Preliminary Acceptance Punchlist
El Paso County – Department of Public Works - Stormwater Section

Project Name:	Glen at Widefield F11
EDARP Filing Number(s):	ESQ2235
ESQCP Number:	SF204, CON2242
Attendees:	DPW SW: Natasha Grimaldo, Christina Prete, and Shannon Mustoe DPW Development Services: Brad Walters, David Parkerson, Amanda Rivera, and Spencer Pirzadeh Developer: Rudy Cross and Ryan Watson
Date of Walk-Thru:	04/10/2024
Walk-Thru Number:	1 st

P 28 DETENTION BASIN TYPICAL CROSS SECTION SCALE: NTS

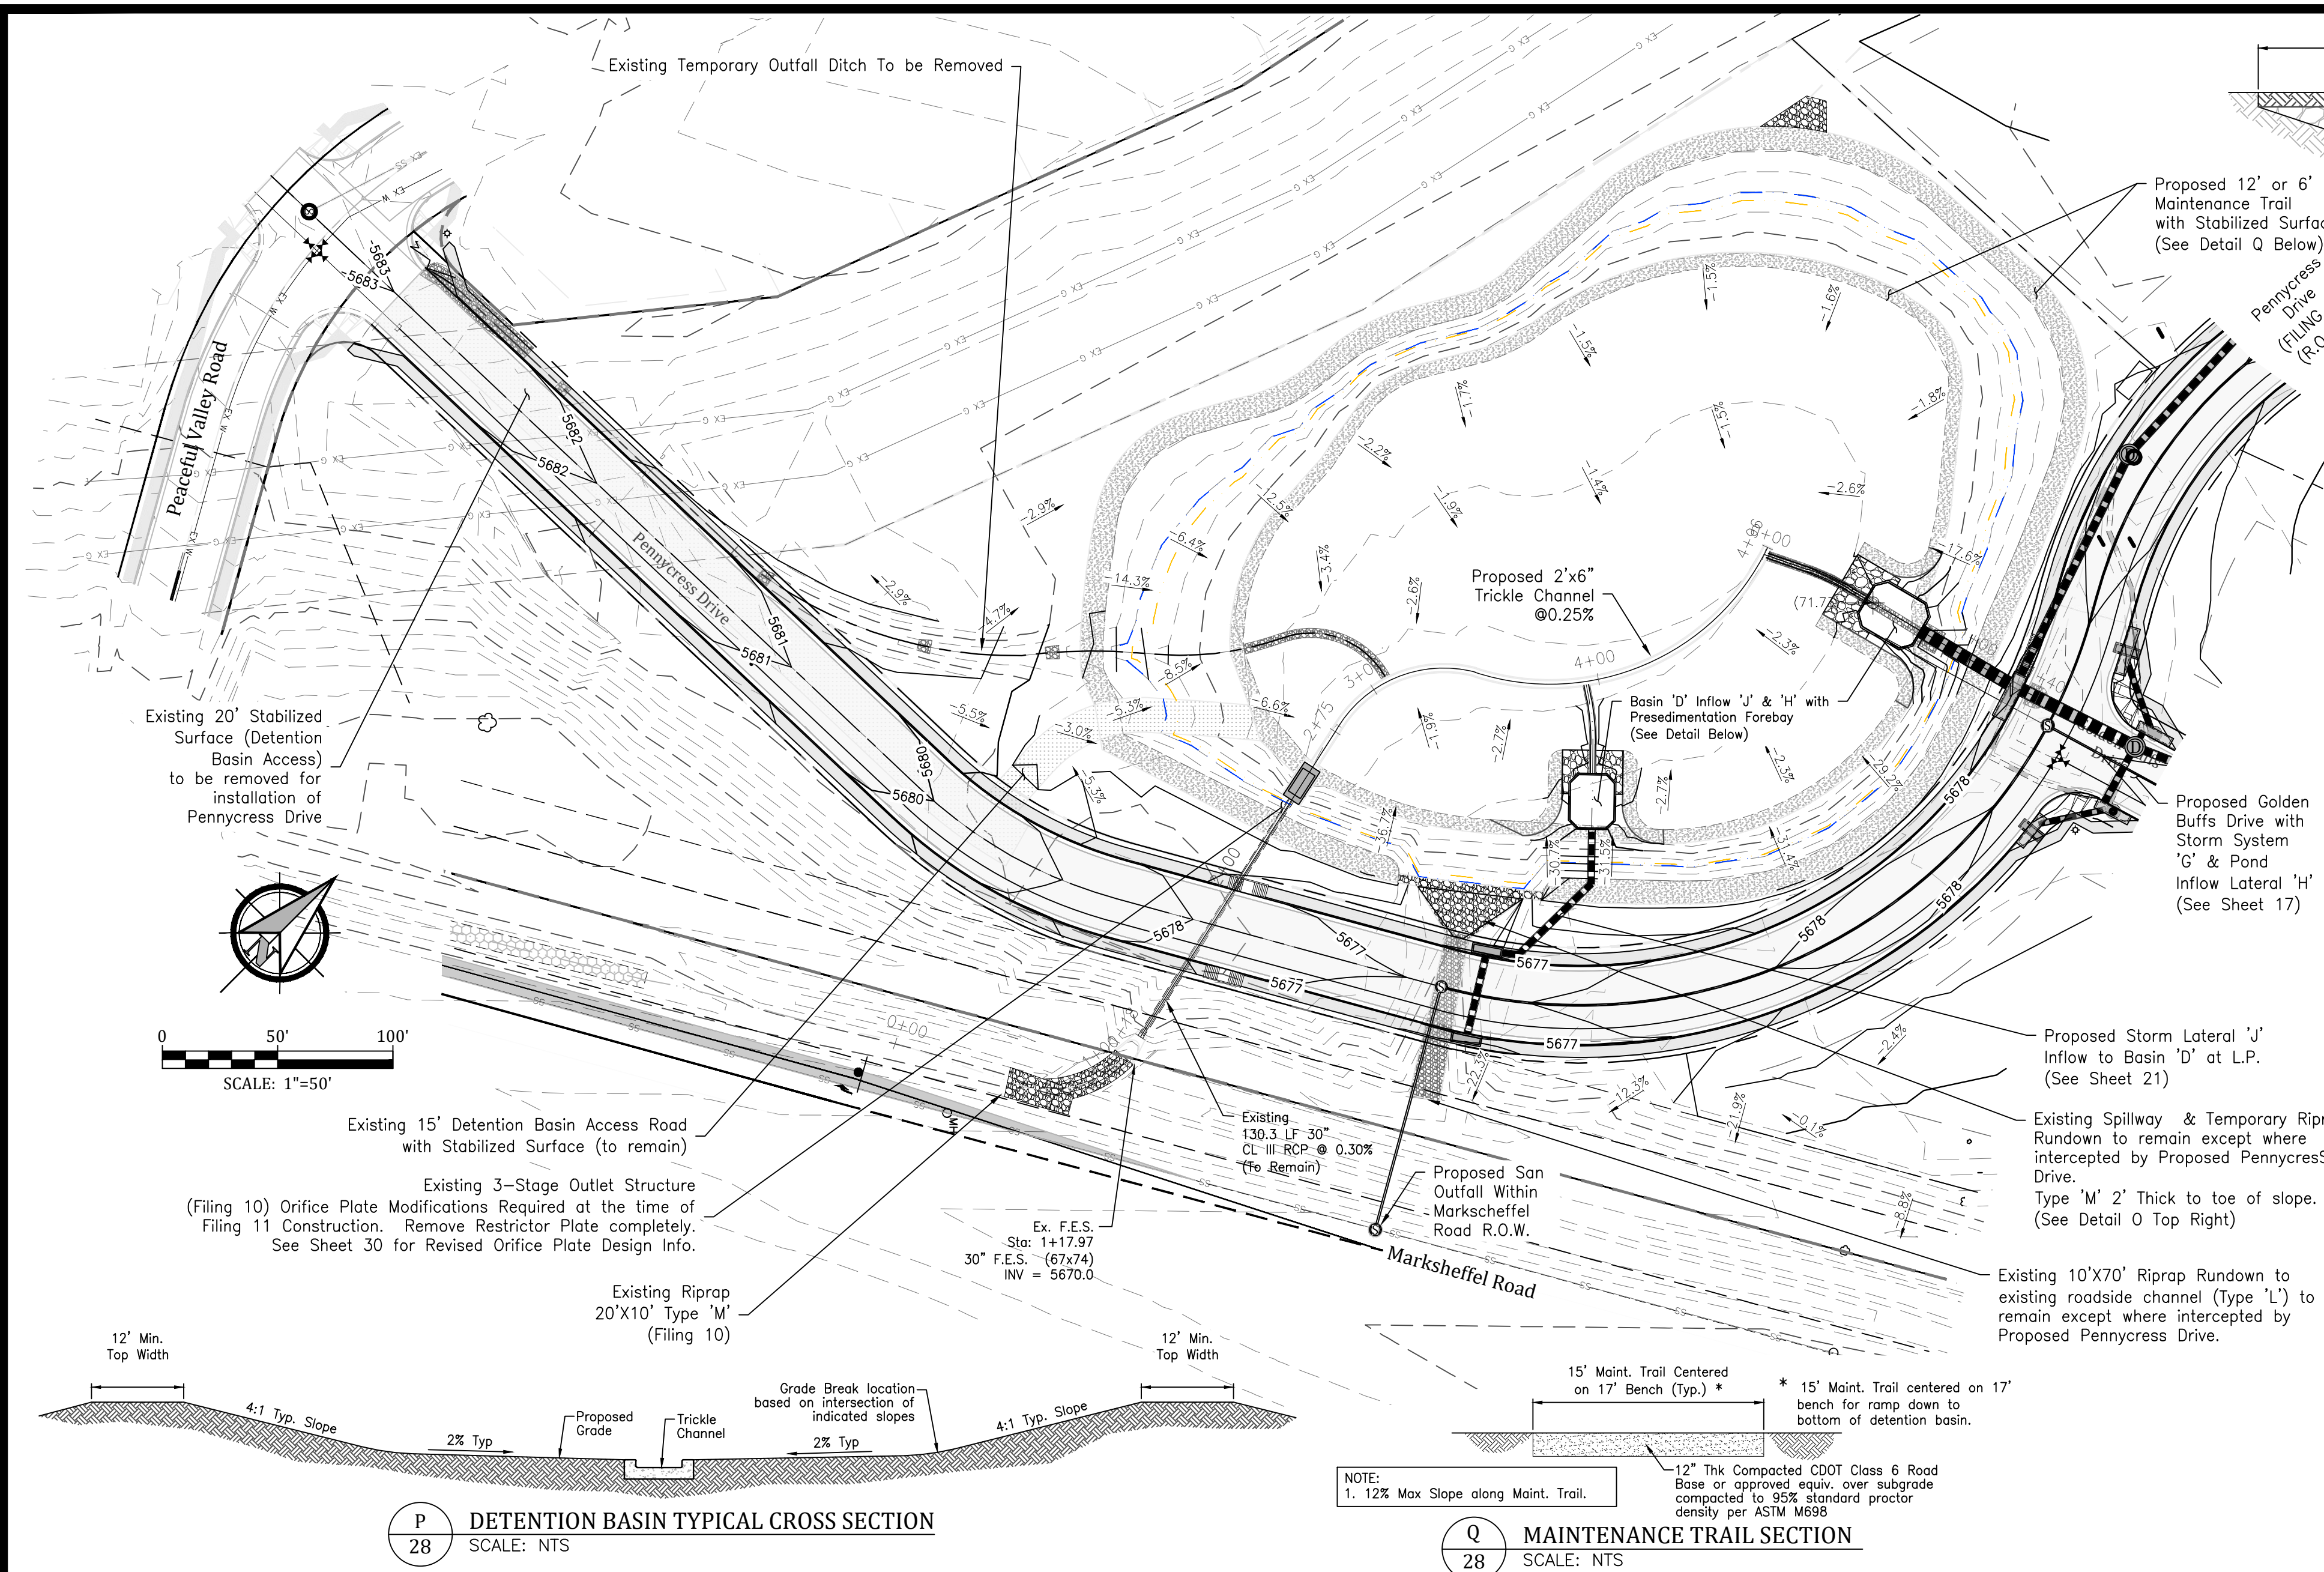
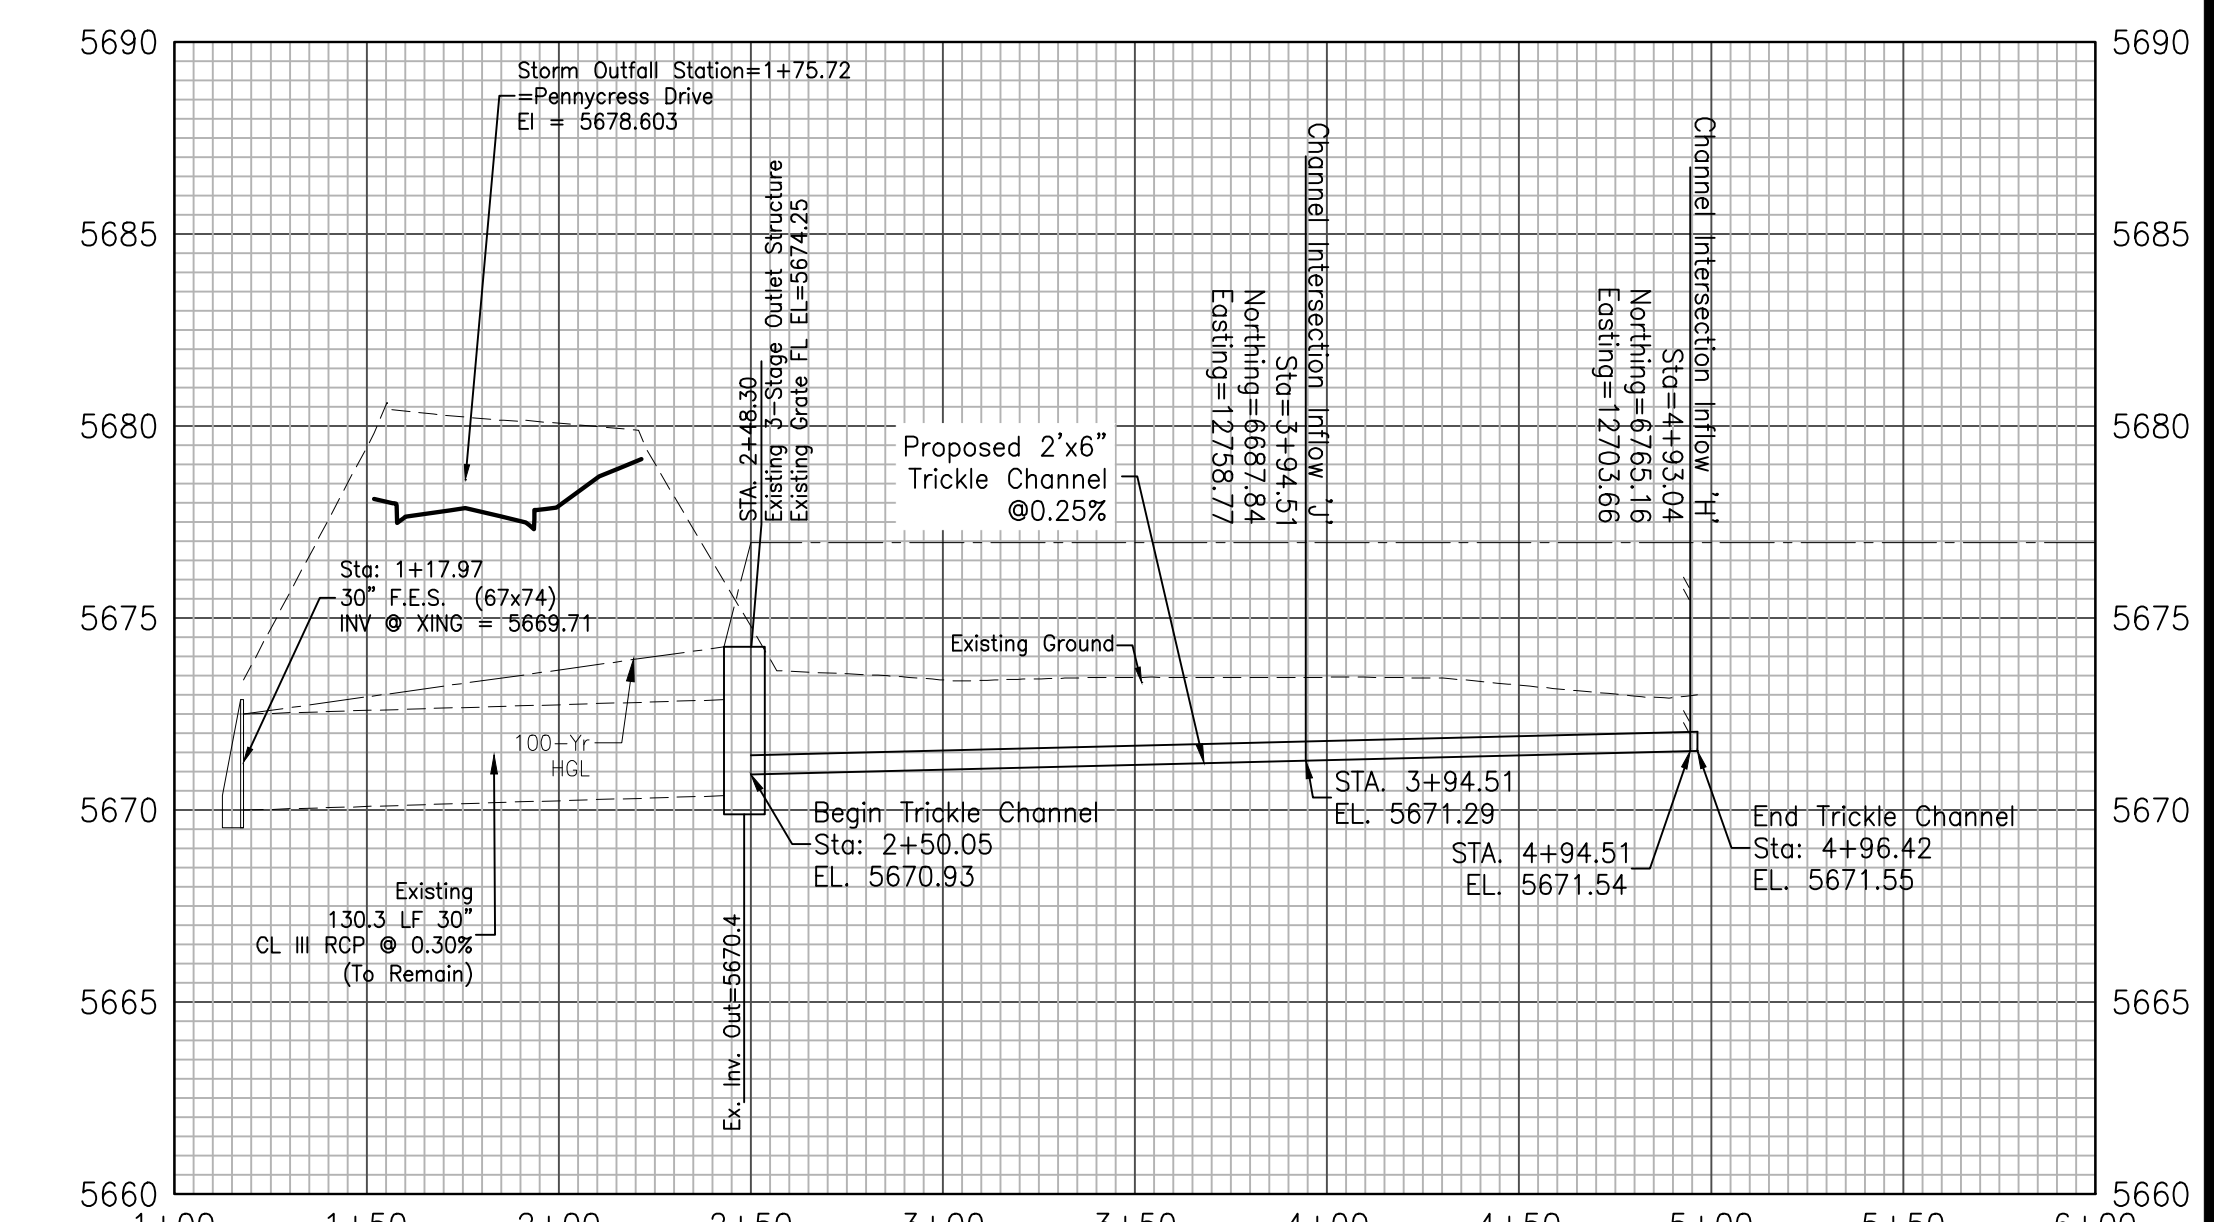
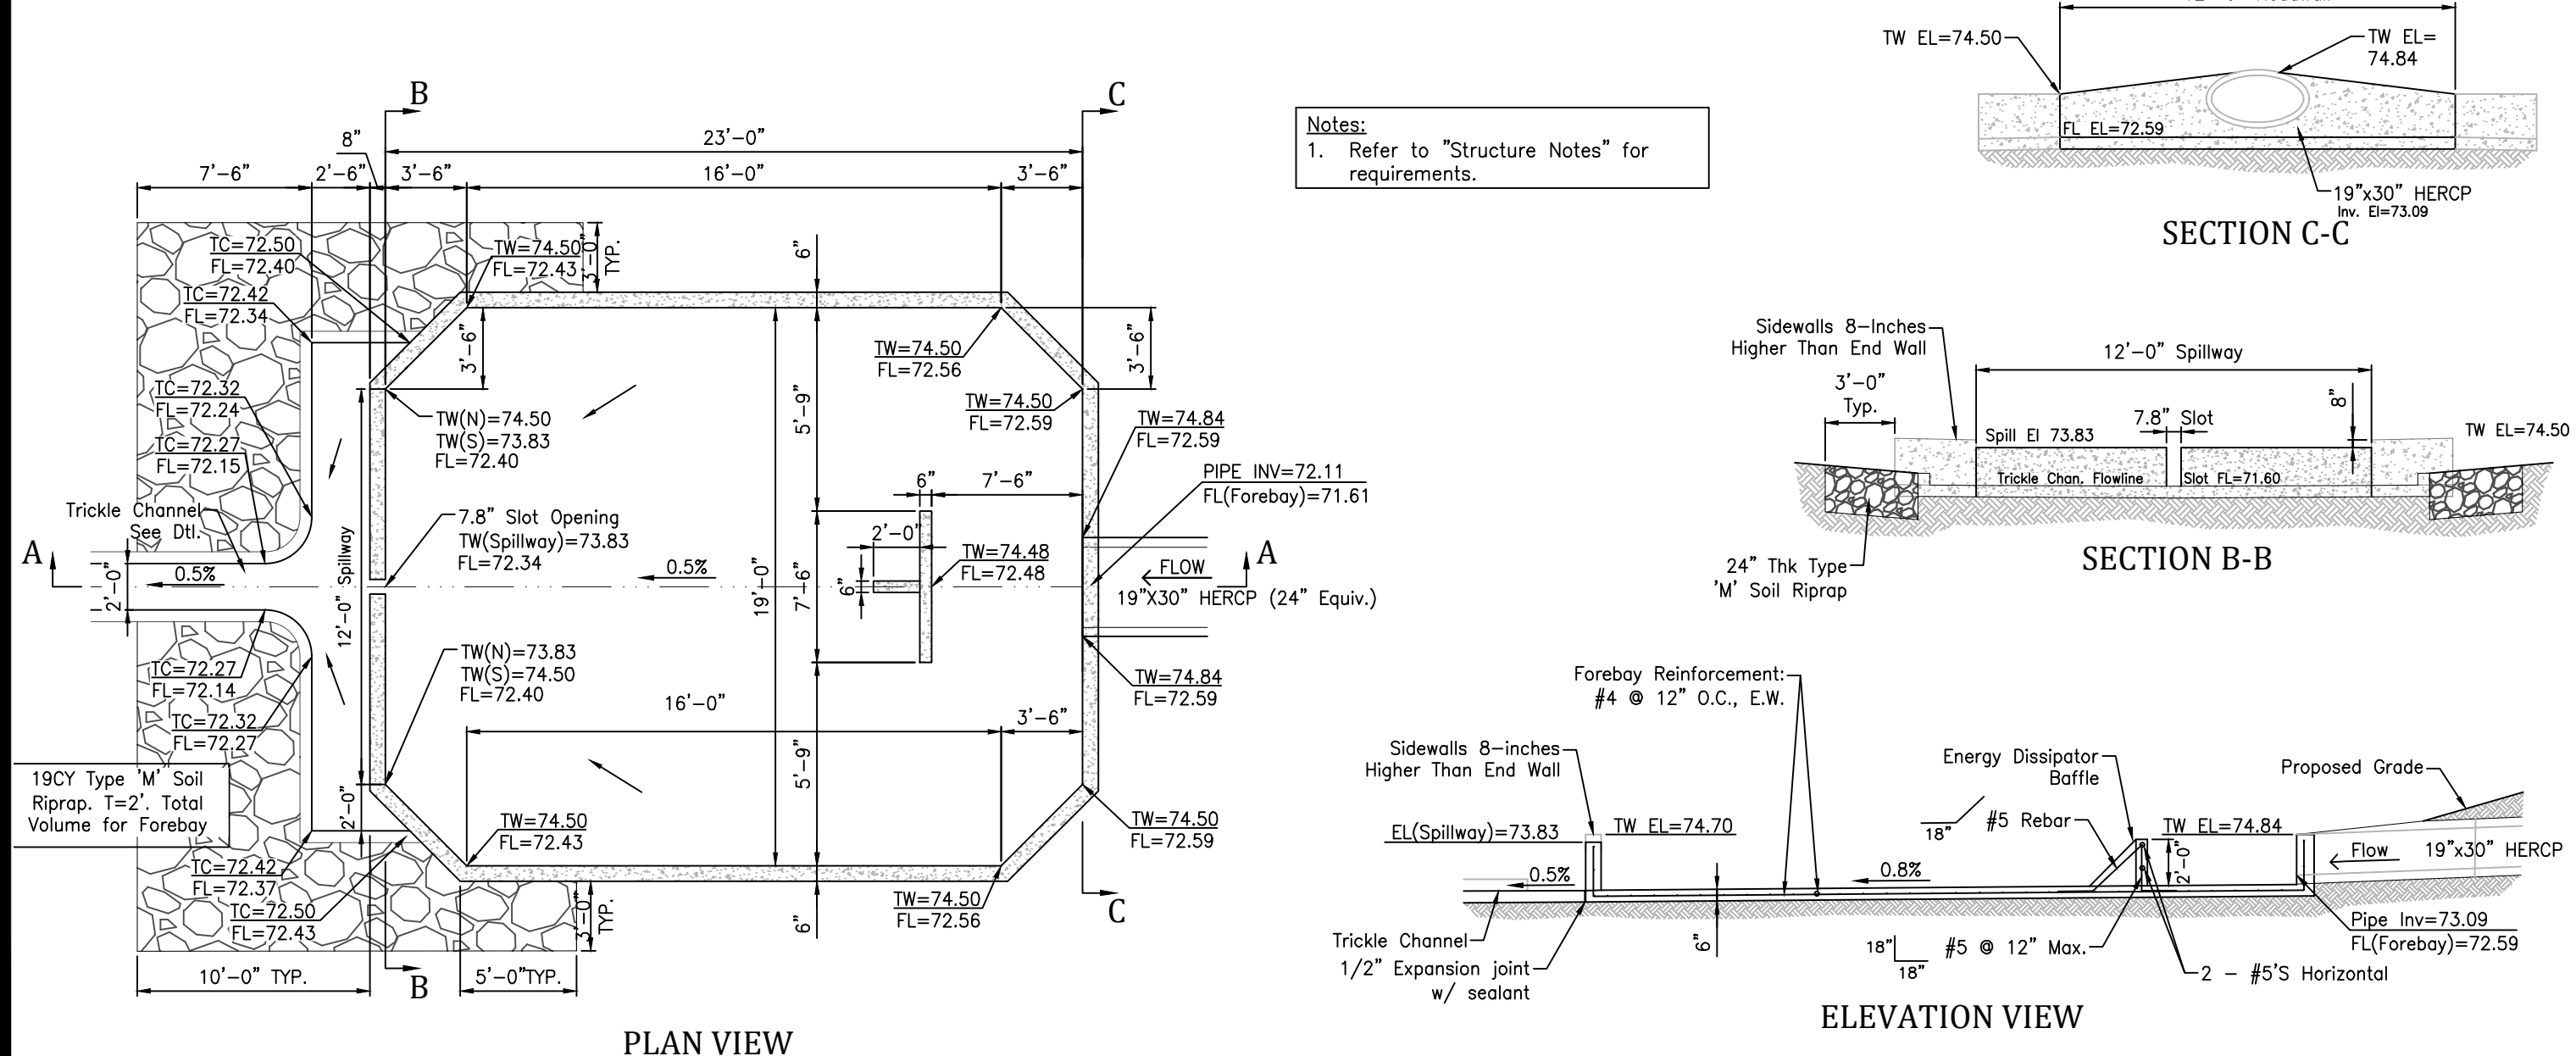
- Emergency Overflow: Confirm installation of soil riprap overflow on the east and west perimeter of Pennycress Dr. Existing spillway and rundown were to remain installed except where intercepted by Pennycress Dr. Reference Sheet 28 of the Construction Drawings. Reference Photos 8 and 10.
- Install Type M soil riprap with 3"-4" topsoil revegetated with seed mix. Current riprap does not consist of all Type M aggregate. Reference Sheet 28 of the Construction Drawings. Reference Photo 9.
- Pond Outfall: Confirm outfall elevation allows for positive drainage. Reference Photo 11.

- Pond Outlet Structure: Remove restrictor plate. Reference the Drainage Report. Reference Photo 14.
- Forebay J: Energy Dissipator Baffle was installed at 5'4" from the inflow pipe. Plans call for a distance of 7'6". Change structure to match approved plans or justify change in the As-builts/Drainage Report. Reference Sheet 28 of the Construction Drawings. Reference Photo 15.

- Forebay J: Inflow pipe measures 34"x53". Plans call for 19"x30". Change structure to match approved plans or justify change in the As-builts/Drainage Report. Reference Sheet 28 of the Construction Drawings. Reference Photo 16.

- Forebay J: Slot opening measures 10.5". Plans call for 7.8". Change structure to match approved plans or justify change in the As-builts/Drainage Report. Reference Sheet 28 of the Construction Drawings. Reference Photo 17.

- Forebay J: Install 16'x2'6" trickle channel at front of forebay per the approved plans. Reference Sheet 28 of the Construction Drawings. Reference Photo 18.

- Forebay J: Forebay measures 13'x17'2". Plans call for 23'x19'. Change structure to match approved plans or justify change in the As-builts/Drainage Report. Reference Sheet 28 of the Construction Drawings. Reference Photo 19.

- Pond: Trickle channel measures 1'. Plans call for 2'. Change structure to match approved plans or justify change in the As-builts/Drainage Report. Reference Sheet 28 of the Construction Drawings. Reference Photo 20.

- Forebay H: Fill in soil riprap to be free of voids and flush with grade. Reference Photos 21 and 22.
- Forebay H: Install 16'x2'6" trickle channel at front of forebay per the approved plans. Reference Sheet 28 of the Construction Drawings. Reference Photo 23.

- Forebay H: Spillway measures 17'11". Plans call for 12'. Change structure to match approved plans or justify change in the As-builts/Drainage Report. Reference Sheet 28 of the Construction Drawings. Reference Photo 24.

- Forebay H: Energy Dissipator Baffle was installed at 6'5" from the inflow pipe. Plans call for a distance of 7'6". Change structure to match approved plans or justify change in the As-builts/Drainage Report. Reference Sheet 28 of the Construction Drawings. Reference Photo 25.

- Forebay J: Forebay measures 18'5"x26'10". Plans call for 23'x19'. Change structure to match approved plans or justify change in the As-builts/Drainage Report. Reference Sheet 28 of the Construction Drawings. Reference Photo 27.

- Pond: Install 15' maintenance access road with 12" Class 6 road base per the approved plans. Reference Sheet 28 of the Construction Drawings. Reference Photos 28 and 29.
